**Consultation Response from KC,
 Trees**
2020/93308 Former Spotted Cow Pub, New Hey Road, Huddersfield, HD3 4BU
Erection of an A1 foodstore with associated parking, servicing areas and landscaping
Date Responded: 17/11/20
**Responding Officer: Nick
 Goddard**
Responding Ref: 61/92

DRAWING TITLE
Culvert Diversion
General Arrangement

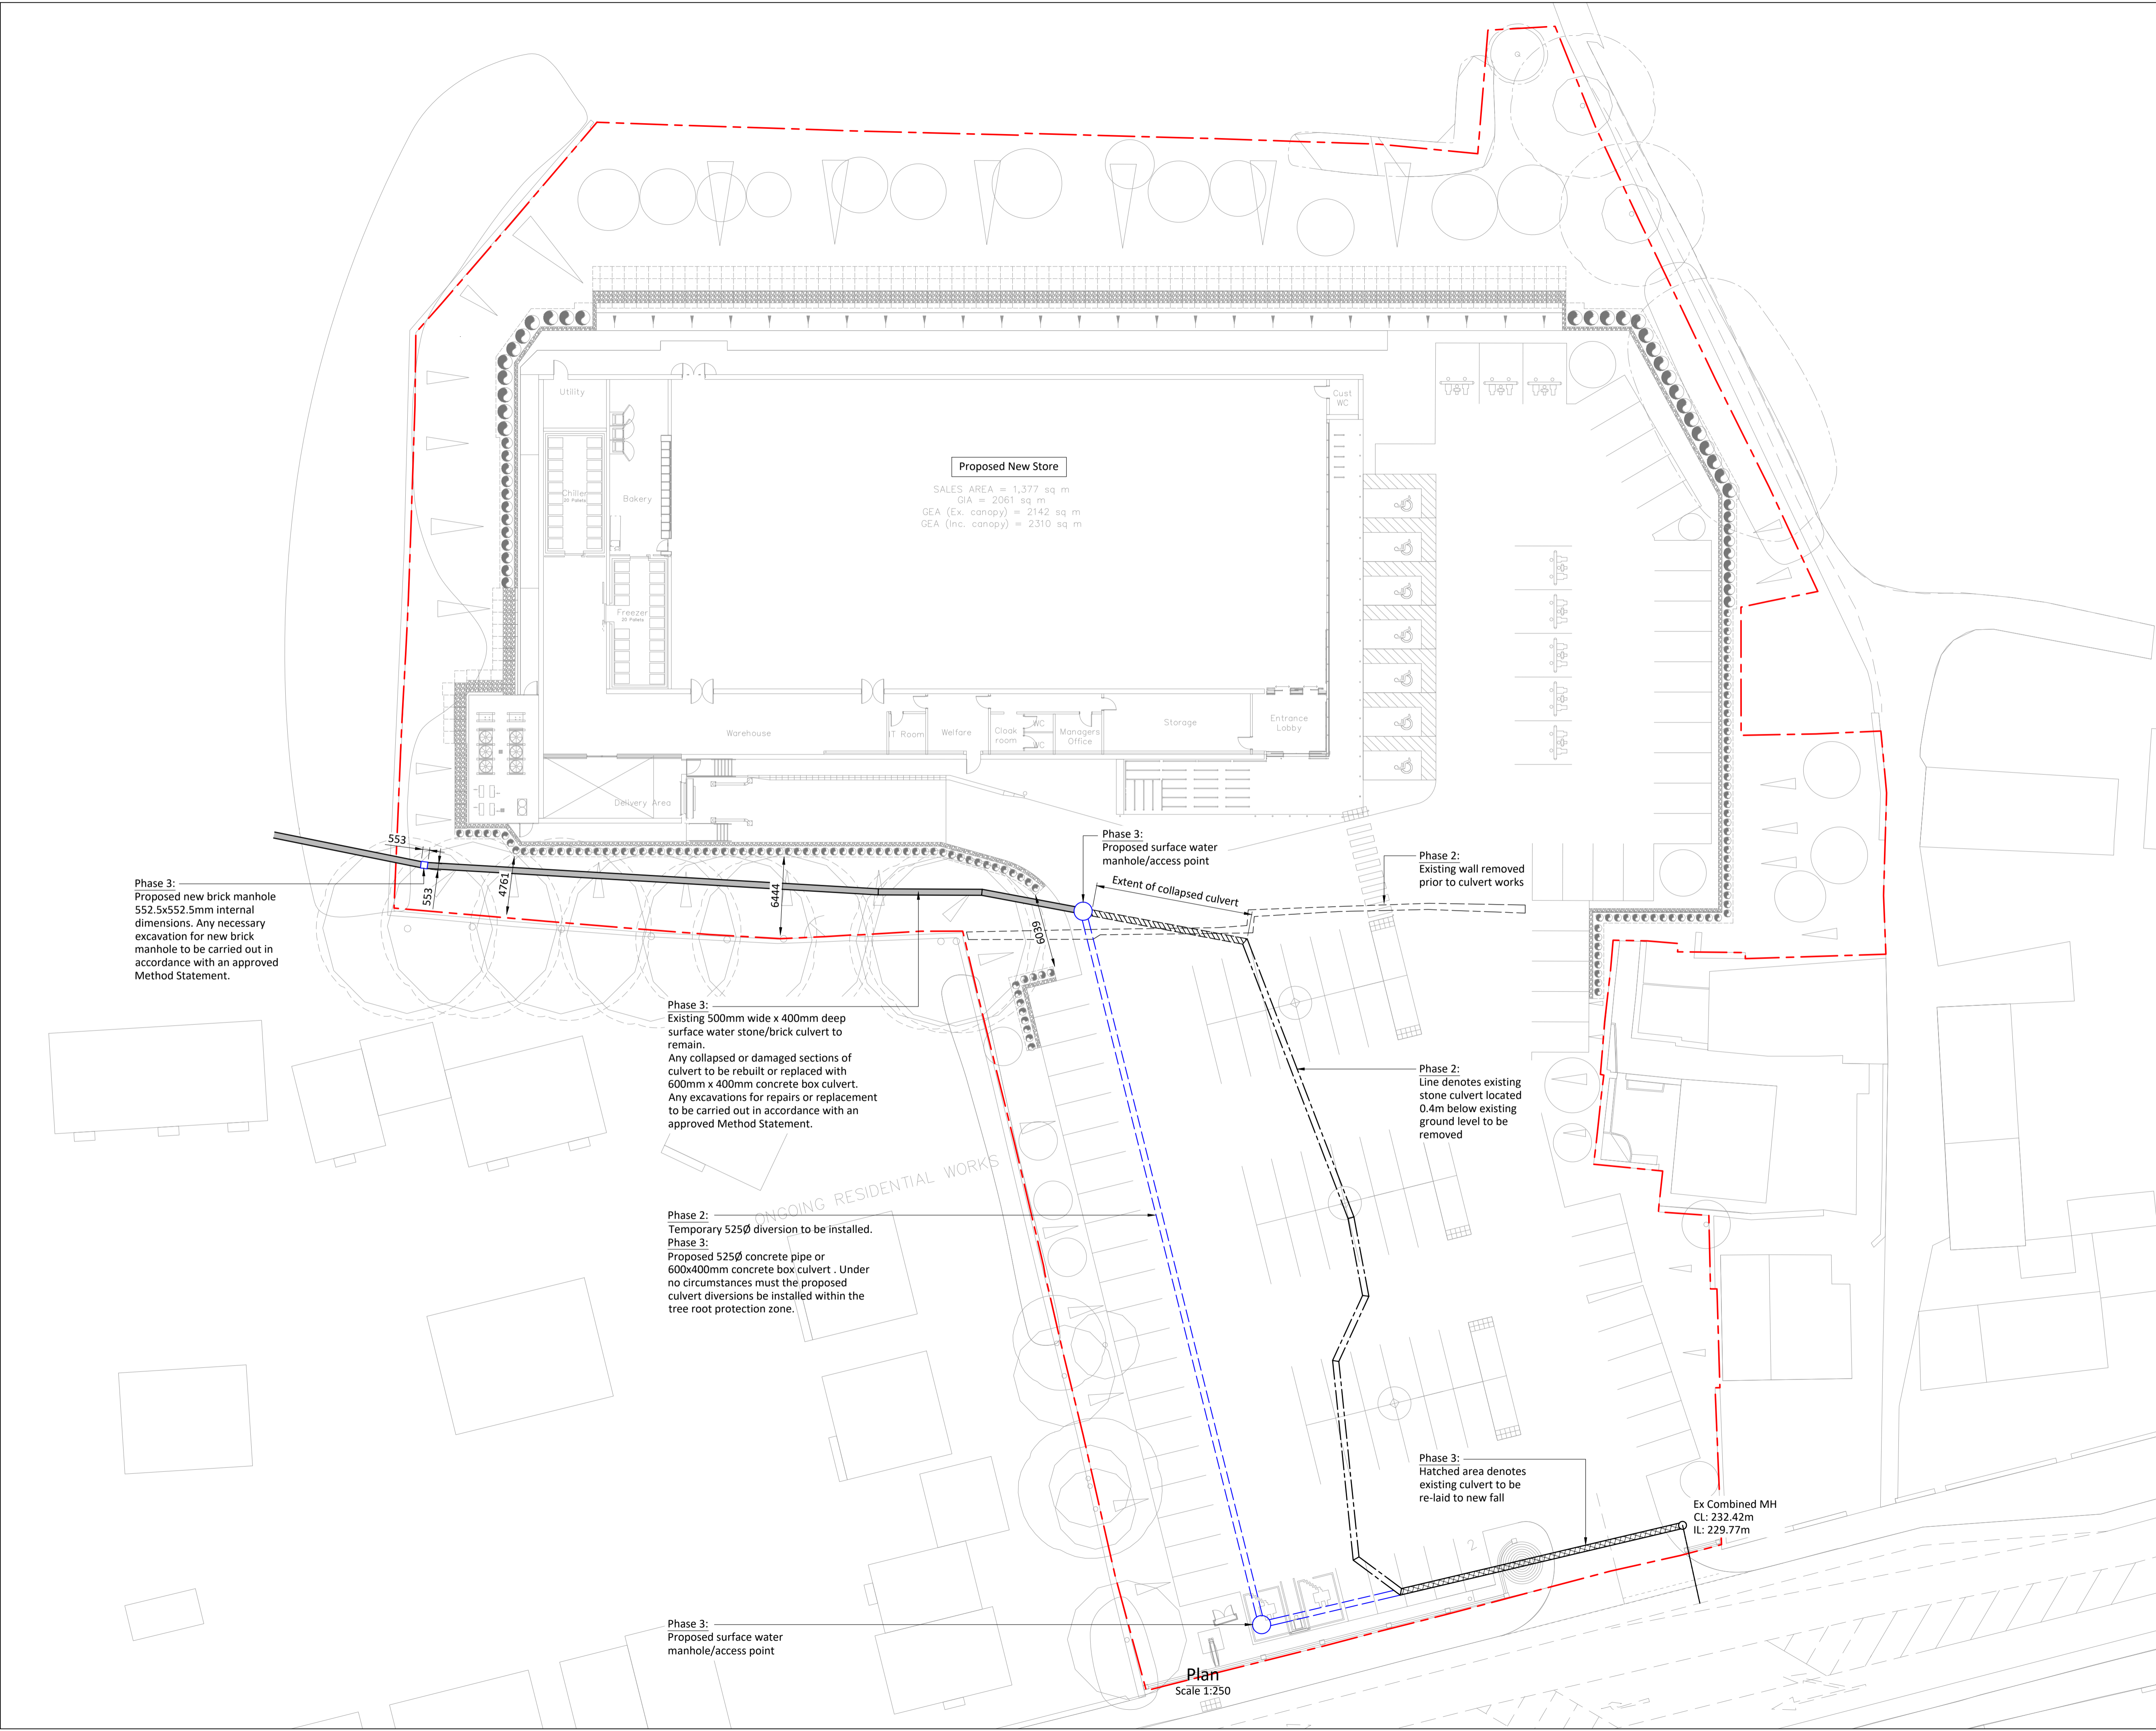
AMS states no utilities will be positioned within RPA of trees however the existing culvert is to be excavated and repaired, where it has collapsed, and to have a new manhole installed within the RPA of G13. According to drawing 09-122-502 this is all to be done in accordance with a method statement and yet no information regarding this work has been provided. Nor indeed has any explanation been given as to why the culvert cannot be redirected under the loading area from the new manhole, this would allow the remainder of the rooting area of these trees to be left undisturbed.

If the culvert has to remain and be repaired it may be possible to provide a method of working to repair any damaged sections of the culvert however it's likely that doing this will result in significant damage to the roots simply because of its location. Can the applicant provide details of how much work is required to repair the culvert and on what sections of it? Presumably this detail will have been considered by the applicant and the culvert surveyed in detail; the specific areas of repair could be shown on a plan to accompany an AMS. Unfortunately, I suspect that once approved we will be informed the whole culvert needs to be replaced and the cumulative effect of this and adjacent housing development could result in the trees' rapid decline and/or loss which is not something I could support.
